From: Jeremy Collins - Ironwood Structural Design
<jeremy@ironwood-design.co.uk>
Date: 8 June 2023 at 10:12:11 BST
To: Wayne Lewis <wayne@lewisproperty.co.uk>
Subject: 2 Market Place & 1 High Street, Woodstock

Further to our meeting at Brothertons Brasserie yesterday afternoon I write to confirm my observations:

Drawing Title: Existing + Proposed Floor Plan's

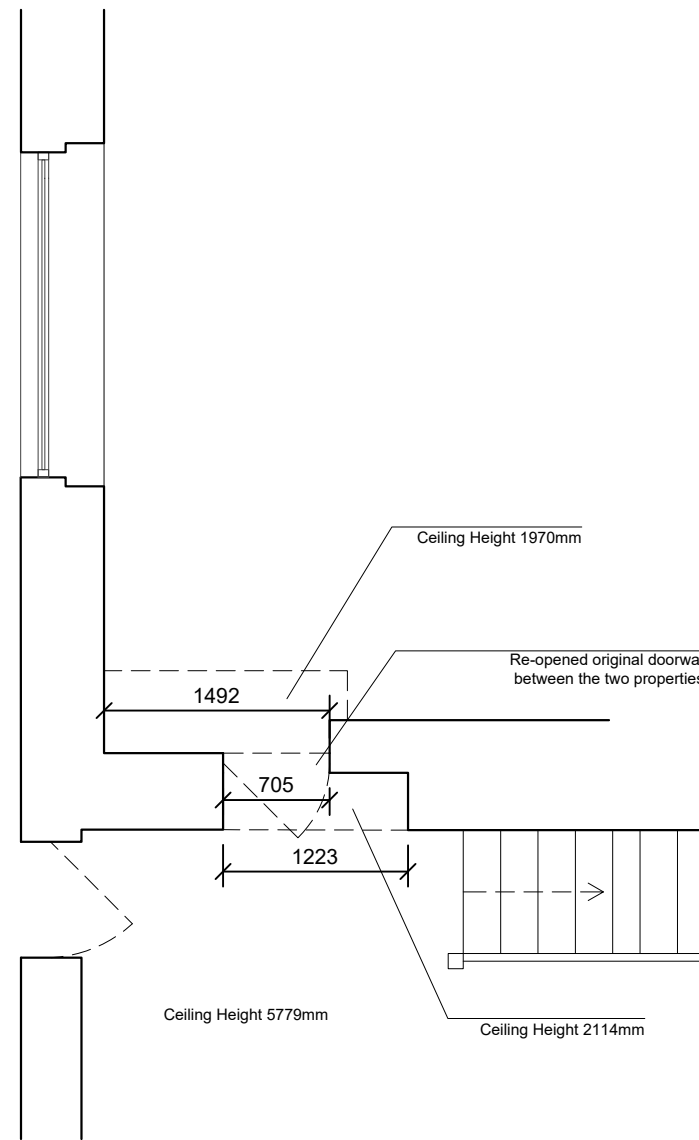
1. There does indeed appear to be an infilled door opening between the 2 units, approx. 250mm / 1 brick thick, within a much thicker original wall.
2. The internal face to 1 High Street appears to have a cement render on it, indicating that it is relatively modern.
3. The timber lintel over, where exposed, appears to be in reasonable condition.

In summary, I cannot see a reason why the opening is not reintroduced. The works should proceed with care.
